Ann Machado - BP#2015-00403 131 Johnson Road - Sign permit zoning review

From: Laurie Leader
To: mason@burrsigns.com
Date: 4/3/2015 12:53 PM
Subject: BP#2015-00403 131 Johnson Road - Sign permit zoning review

131 JOHNSON ROAD - Building Signs
 Scale: NTS
 Square Footage: 32

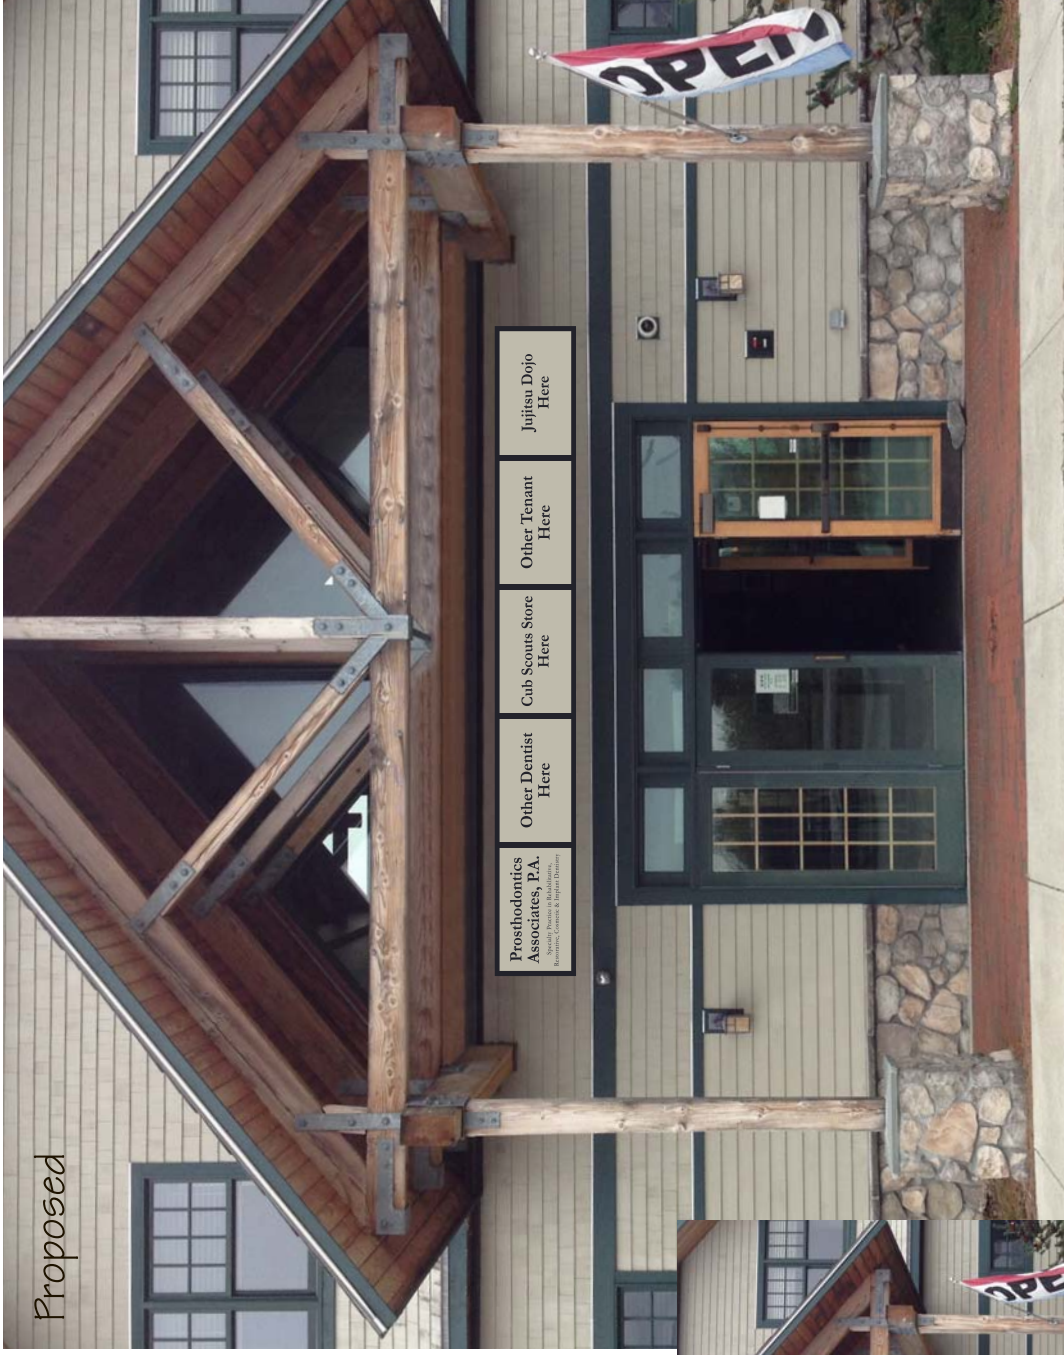
3. The building sign states Jujitsu Dojo here. This is not a permitted use for the building. In order to have this permit approved, the tenant will need a change of use approved prior to this approval. The other option is to leave the sign blank and apply for that sign permit at a later date.

4. Clarify if Prosthodontics Associates, P.A. and Southern Maine Oral & Maxillofacial Surgery are occupying the same tenant space or completely separate tenancies? Add the second dentist sign on the building sign rather than stating "other dentist here".

131 JOHNSON ROAD - Multi-Tenant Pylon
 Scale: NTS Square Footage: 69

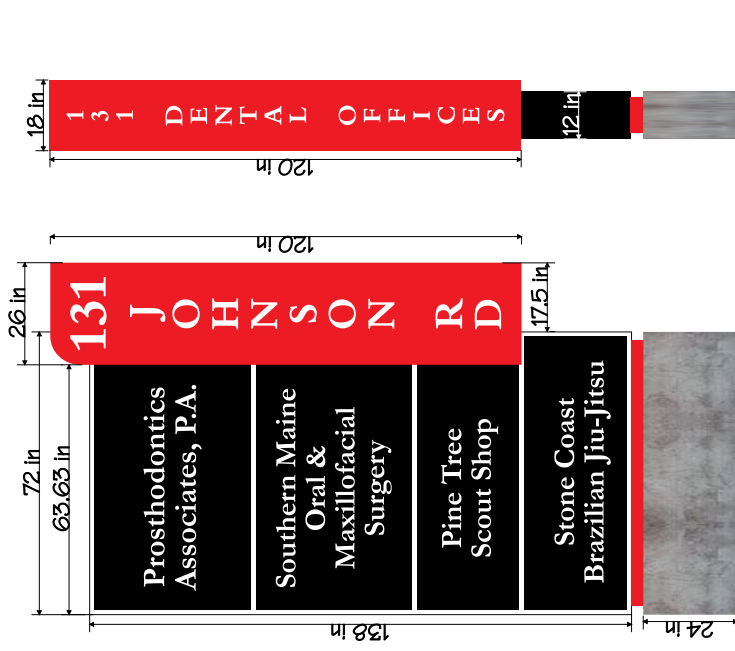
1. The sign must be 5 feet from the property line. It is shown to be 10 feet from the road but does not reference the actual property line. Please revise.

2. When providing calculations for the free standing sign, square footage calculations must include the square footage for the 131 Johnson Road portions of the sign as well. According to my calculations, the sign exceeds the allowable 100 square feet. Please revise to meet allowable zoning.

5. Clarify that the existing sign will be removed.
